Our Reference: SYD20/00773/03
Departments Reference: SSD-10479

EXHIBITION OF EIS - 106-228 ALDINGTON ROAD - KEMPS CREEK

The documentation, including *AsonGroup Transport Assessment Report* (TAR), in support of the proposal has been reviewed and comments and recommendations are provided in **Attachment A**.

Drawing No. 19-609-C1135	Project No. 19-609	Issue A
-----------------------------	-----------------------	------------

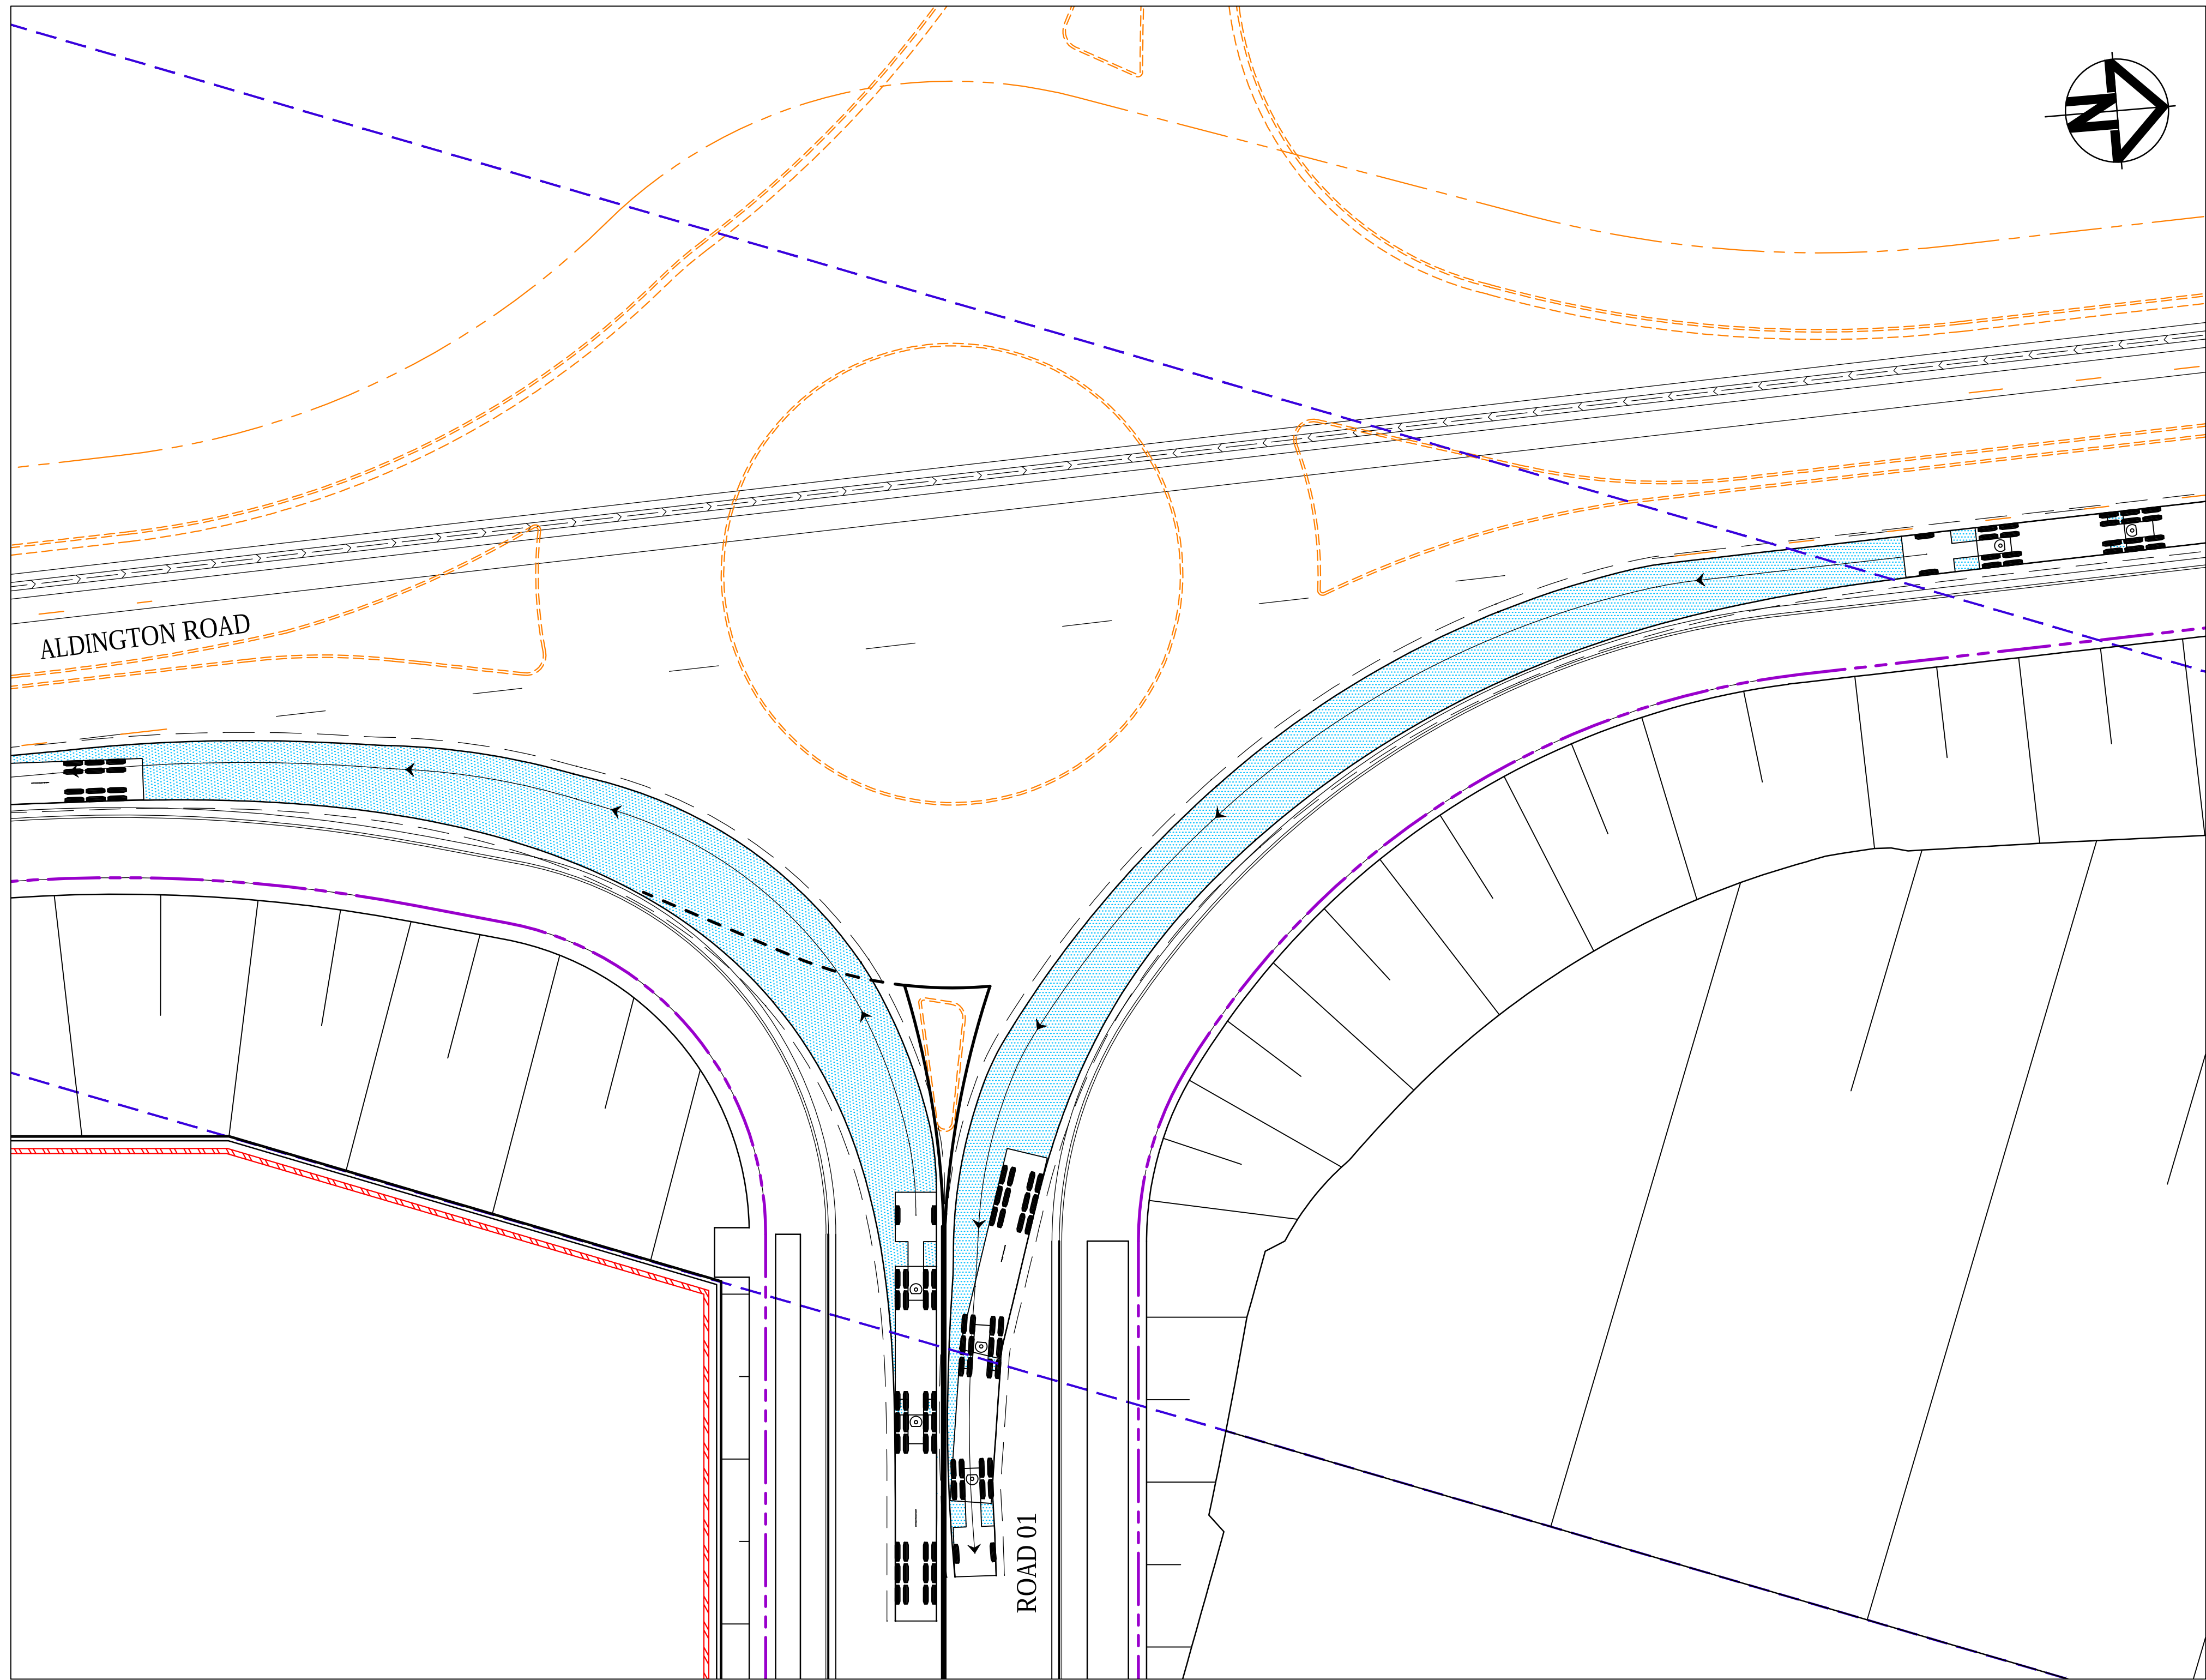
- d. Appendix B - the SIDRA results for the signalised intersection on Mamre Road/Abbotts Road show 80 seconds as the cycle time. The cycle times of all intersections should be modelled as a worst case scenario, this is achieved by using the maximum cycle time for the intersection. In this regard the model should be updated to use the correct maximum cycle time of 140 seconds.
- e. Appendix C - The swept paths provided are of an articulated vehicle (19m). Swept paths will be required to be provided to accommodate the largest type of heavy vehicle which could reasonably be expected to service the site. The WSEA SEPP outlines the required vehicle lengths to be accommodated for.

In this regard, the design vehicle for the access to the site should be assessed with a 26m B-Double and a 30m PBS 2B vehicle. In addition, all swept paths are to be provided including the roundabouts.

TfNSW requests the abovementioned information to be addressed/provided for further assessment prior to the determination of the application. TfNSW will further review and provide response upon receipt of the additional information.
